Confederated Tribes and Bands
of the Yakama Nation

RE: Currier Creek Estates Division 3 & 4 (LP-10-00013)

MEMORANDUM

TO: Phil Rigdon, Deputy Director, DNR
THROUGH: Scott Nicolai, Yakima Subbasin Habitat Coordinator, YKFP
FROM: John Marvin, Habitat Biologist, YKFP
DATE: Tuesday, August 03, 2010
RE: Currier Creek Estates Division 3 & 4 (LP-10-00013)

CURRIER CREEK ESTATES - DIV. 3 & 4
 PART OF SECTIONS 27 & 28, T. 18 N., R. 18 E., W.M.
 KITTITAS COUNTY, WASHINGTON
 - PRELIMINARY PLAT -

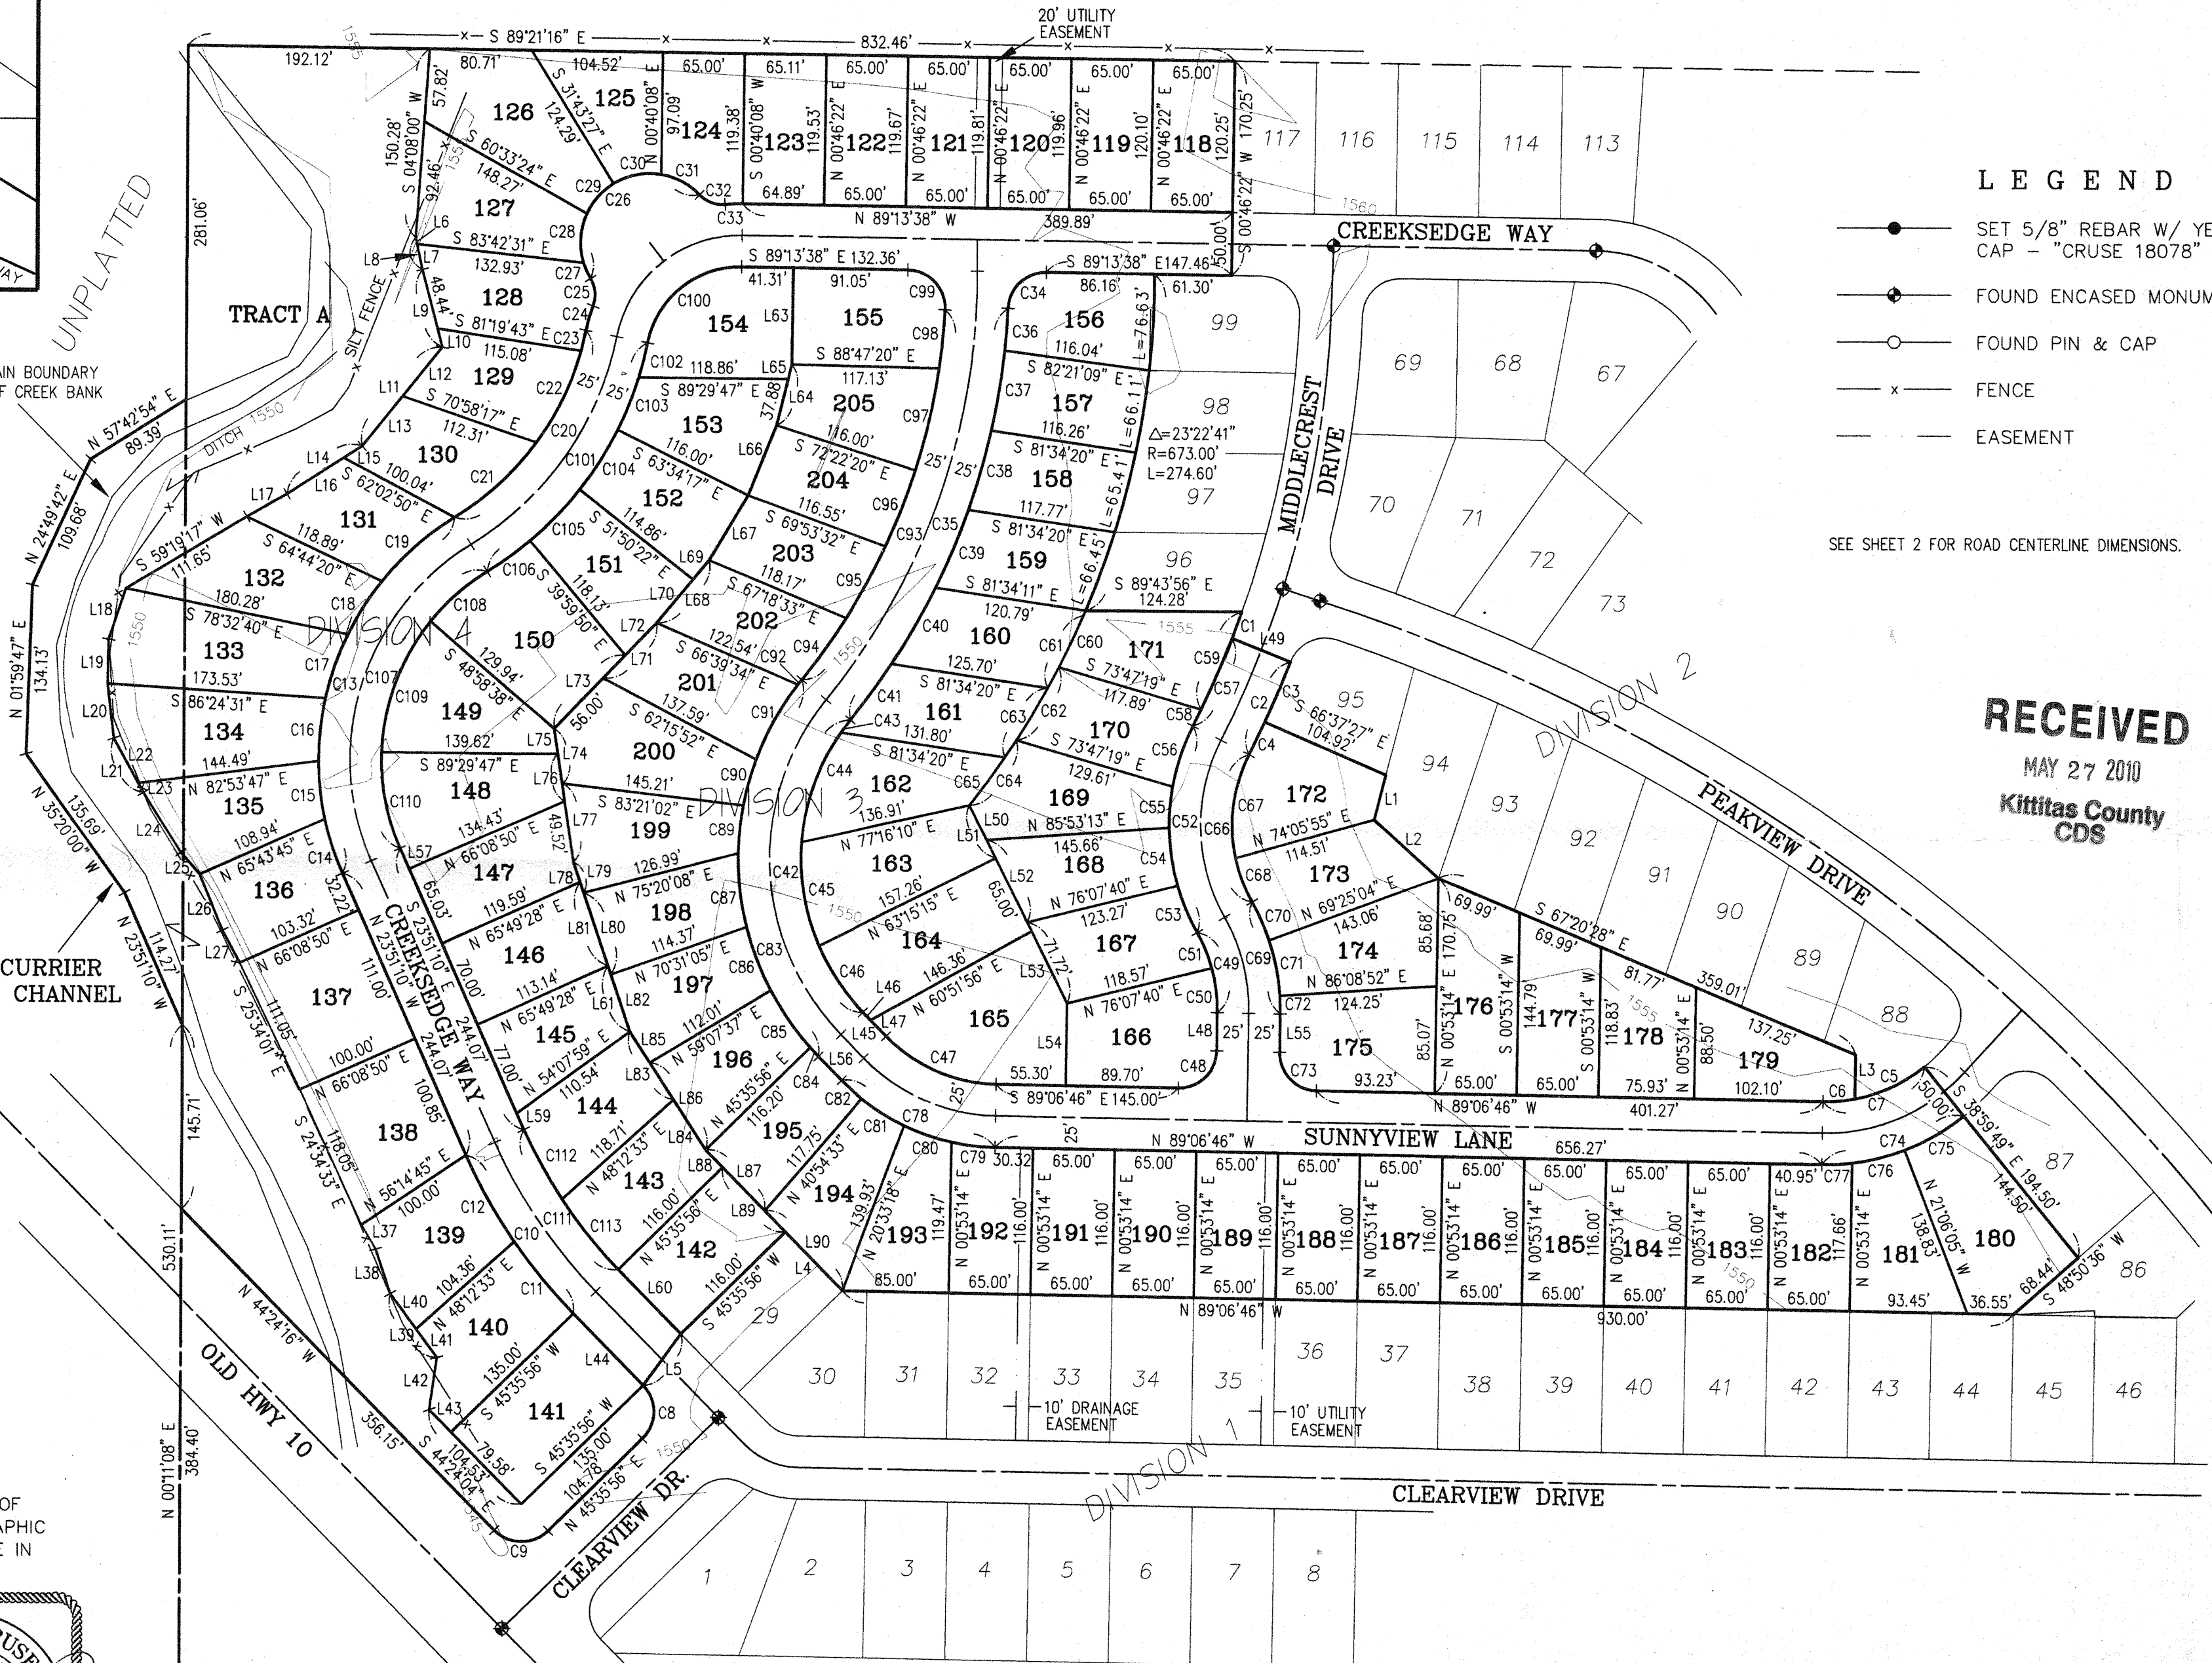
A review of the application and site knowledge indicate that an illegal levee has been constructed along Currier Creek. A levee was never proposed as part of the project nor was it a subject of the project's previous SEPA review. The levee has reduce floodplain conveyance and storage, and directs additional flood water onto adjacent properties.

The FIRM does not correctly identify the area inundated by floods. Portions of Currier Creek Estates lots west of Creekside Way were inundated with water in the flood of 2009.

- The application should be placed on hold until the illegal levee is removed.
- Based on these comments, the project should receive a determination of significance under SEPA. In lieu of a determination of significance, the SEPA review should be conditioned to:
 - conduct a site specific engineering analysis to determine the BFE for the project site., in accordance with KCC 14.08;
 - provide analysis prepared by a certified, registered professional engineer demonstrating through hydrologic and hydraulic analyses performed in accordance with standard engineering practice that the proposed encroachment will not result in any increase in flood levels during the

- occurrence of the base flood discharge., in accordance with KCC 14.08.300;
- demonstrate that the cumulative effects of the proposed development, when combined with all other existing and anticipated development will not increase the water surface elevation of the BFE more than one foot at any point within the community and is consistent with the technical criteria contained in Chapter 5 (Hydraulic Analyses) of the Flood Insurance Study: Guidelines and Specifications for Study Contractors, FEMA-37, 1995;

- demonstrate through an engineering analysis a “no-rise” certification. This certification must be supported by technical data and signed by a registered, professional engineer. The supporting technical data should be based on the standard step-backwater computer model used to develop the 100-year floodway shown on the local FIRM or Flood Boundary and Floodway Map and the results tabulated in the Flood Insurance Study
